Subject: FW: planning application AW/48/21/HH. 17 KINGSWAY BOGNOR REGIS

Subject: planning application AW/48/21/HH. 17 KINGSWAY BOGNOR REGIS

block plan
1 : 500

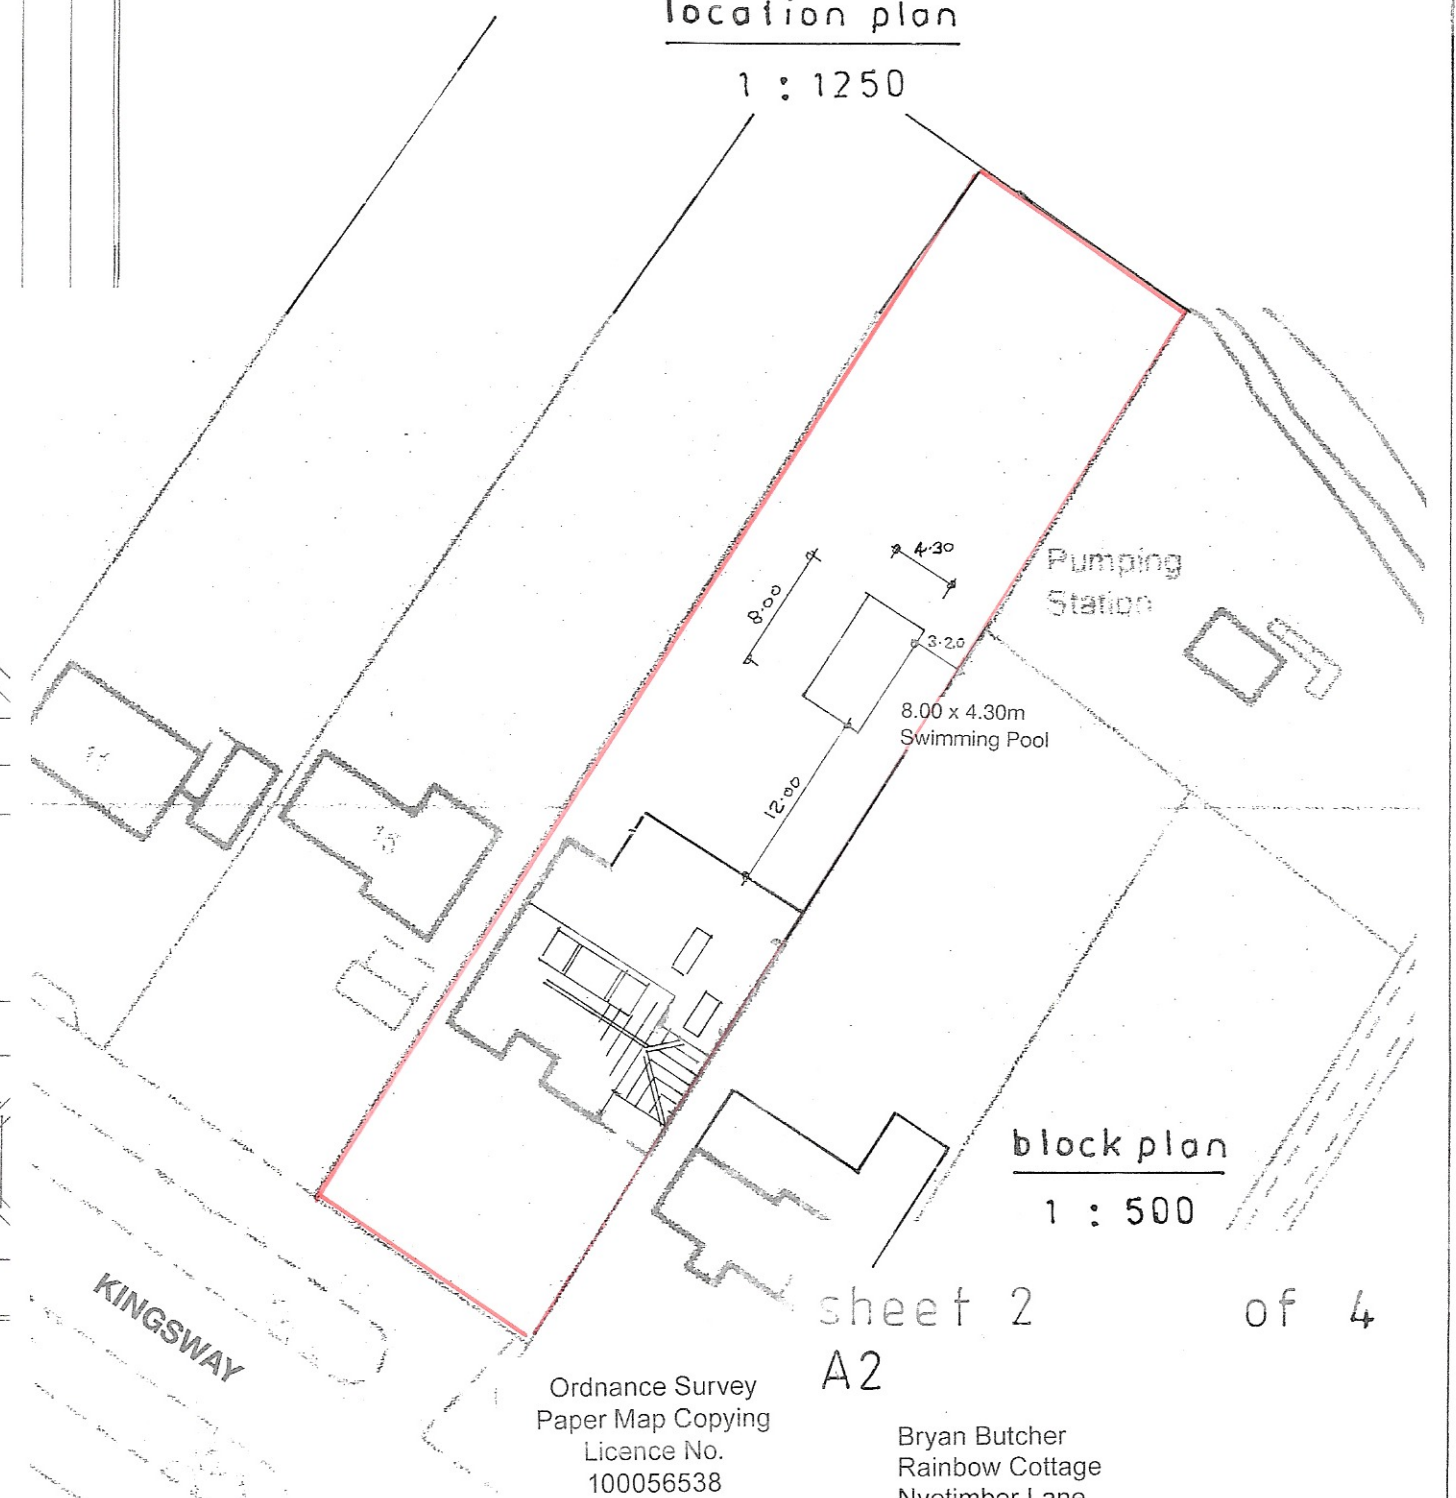
the above planning application also shows the siting of a swimming pool but no further details. At some time there had been a fountain at the bottom of the garden of no 17 as a derelict tank and pipe were discarded in that part adjoining the culvert.

Craigweil is a quiet estate with no background noise such as the hum of constant traffic and the introduction of pumps , filters, cleaning systems and whatever else is needed will affect not only the long narrow gardens on either side but the local area. The drainage will also be affected, at a time when it has to cope with more than usual rainfall.
